Response to Submissions

Werris Creek Coal Mine Modification 2 (PA 10_0059)

June 2015

Figure 5: Proposed Final Landform

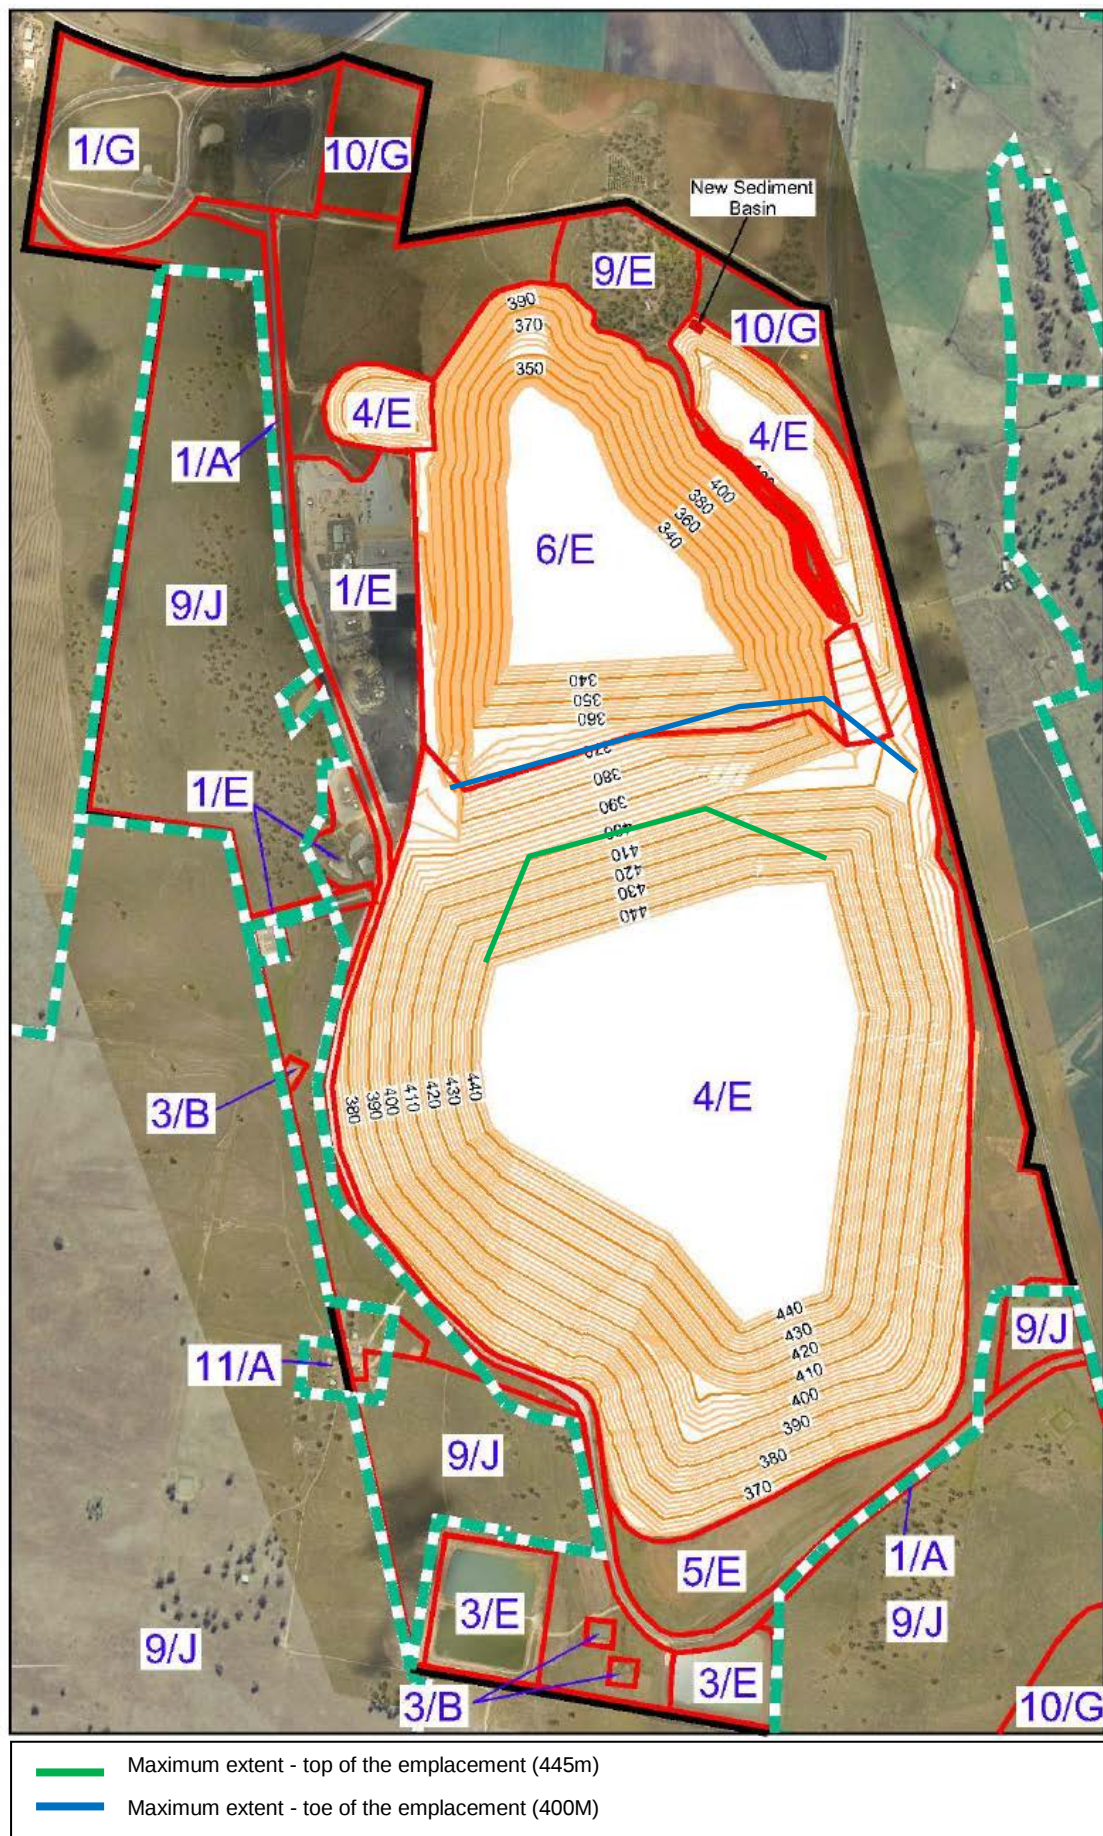
The Department encourages mine operators to design and construct overburden emplacements that have a landform which is sympathetic to the local topography. Such a landform will typically exhibit apparent relief in height and limit the extent of large 'plateau' areas (unless such features are typical of the local topography). Werris Creek Coal Pty Ltd should endeavour to take into account landform design under this philosophy as far as is practical in its proposed modification. '

DRE considers the proposed modification will result in a final landform formation that is not consistent with current rehabilitation objectives, as table tops are not sympathetic with local topography. However, DRE notes the Proponent's statement in the EA that to construct a more distinct "hill top" would require an increase in overburden emplacement height which would contradict commitments made in the 2010 EA for the Werris Creek Mine (RWC, 2010) and on which the current consent was granted...

The planned final landform for the Mine conforms with that previously approved by PA 10_0059. Critical features of this final landform are as follows.

The Applicant notes the DRE's position that the plateau section of the overburden emplacement does not represent a landform which is 'sympathetic to the local topography'. While the Applicant acknowledges that the 'table top' feature of the overburden emplacement is not one which occurs in the surrounding locality, however, does consider that the design of this feature is sympathetic to the surrounding setting based on the following.

- The upper surface of the overburden emplacement will be separated into five separate sub-catchments, with minor rises and falls within each sub-catchment incorporated into the final design. Rather than being table flat, an average fall of 1% to 2% from a central location to the outer edges of the upper surface will be created.

Figure 6: Predicted Worst Case Noise Levels

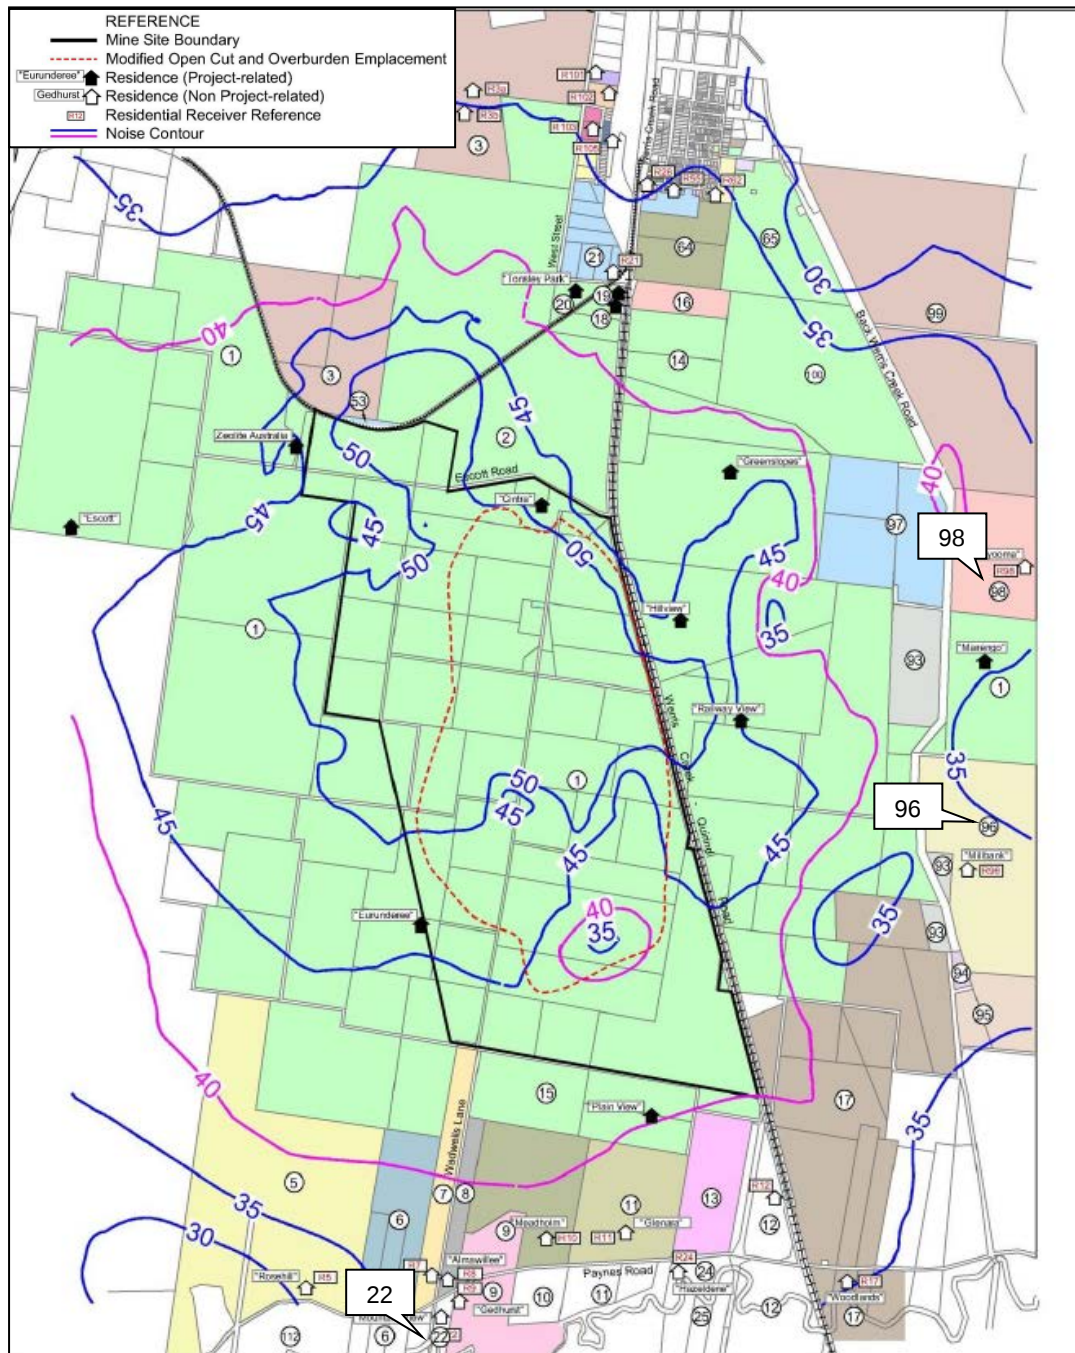
- *The EPA notes that the proponent has negotiated noise agreements with the owners of R22 and R98 that require it to implement additional noise mitigation measures at the residence in the event that noise levels exceed 40dB and acquire the property if noise levels exceed 45dB. The EPA recommends that these agreed commitments are reflected in the noise limits established for the modification to ensure that the terms of this agreement are legally binding (i.e. apply limits of 40dB at each of these residences unless and until additional noise mitigation measures are applied at the relevant residence, in which case the limits should then increase to 45dB unless the residence is acquired by the Applicant.*

- *This leaves receptor R96, which the EPA recommends should be provided with noise mitigation rights within the modified project approval to be consistent with the way other receptors within the 5dB noise affectation zone have been treated in the past.*

The Applicant accepts the recommendations of the EPA with respect to the establishment of modified noise criteria conditions. As R96 is currently identified in PA 10_0059 Schedule 3 Condition 3 for Additional Noise Mitigation Measures, no change to PA 10_0059 is required.

Figure 7: Indicative Location of Void Water Irrigation

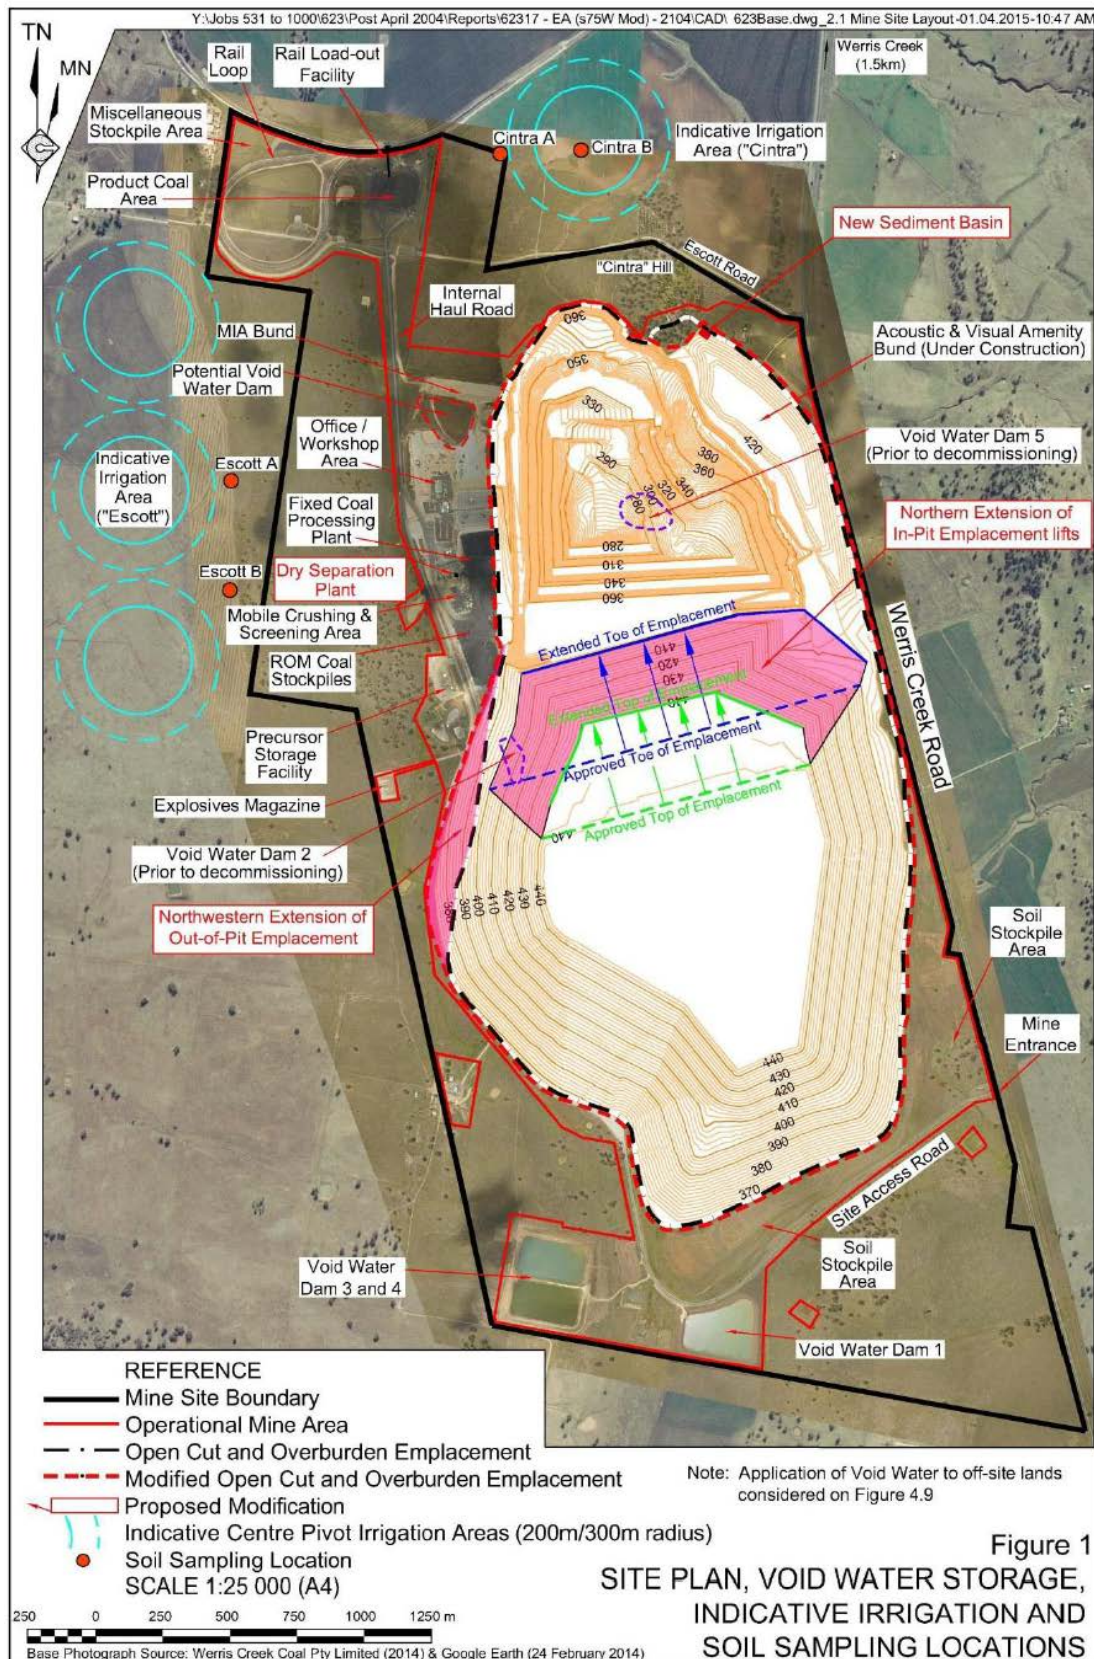
- *The EPA is concerned that the proposal to allow the irrigation of void water has been presented as something that will only be pursued in the event that wet conditions are experienced. The water balance modelling presented in the EA indicates that insufficient out-of-pit void water storage is available to cater for a 90th percentile wet year. If irrigation is not pursued until wet conditions are experienced there is a risk that such intervention will be too late to prevent an uncontrolled discharge of void water from the site. Furthermore, in a wet year, irrigation is generally not required to supply the water requirements of any crop, and there may be a significant lead time required to install the necessary irrigation infrastructure and establish a suitable crop for irrigation purposes.*

- *The EPA concedes however that it may be possible to irrigate the void water without causing soil degradation or water pollution, if appropriate safeguards and management measures are implemented. It is therefore recommended that the modified project approval requires the proponent to prepare an irrigation management plan in close consultation with the EPA, for approval by the DPE. This proponent should be required to prepare and submit this plan within a maximum period of 3 months. The plan should then be implemented within a further 3 months to ensure that stored void water volumes can be utilised without unnecessary delay in order to maximise available storage at all times in order to cater for a potential wet year during the remaining life of the mine. ...Alternatively, the proponent should be required to implement other means of ensuring it can contain the void water generated by the site (e.g. expanding out-of pit void water storage capacity, employing additional evaporators etc.).*

In the teleconference of 21 May 2015, the Applicant explained to the EPA that the use off-site use of void water would not be restricted to the high rainfall scenario, rather this scenario of the water balance was referenced in the Irrigation Assessment and *Environmental Assessment* as it illustrates the likely maximum quantity of water which might require irrigation for assessment

As identified in Section 2.5.4.3 of the *Environmental Assessment*, the Applicant has committed to undertaking site specific irrigation assessments following confirmation of contractual arrangements between the Applicant and user of the water. Each site specific *Pre-Agricultural Void Water Use Assessment* will outline the proposed irrigation method and detail the estimated water application rates. The Applicant is happy to consult with the EPA and the DPE in completing these assessments, and comfortable with the conditions on timing proposed by the EPA for updating the Site Water Management Plan to include the option of agricultural use of void water.
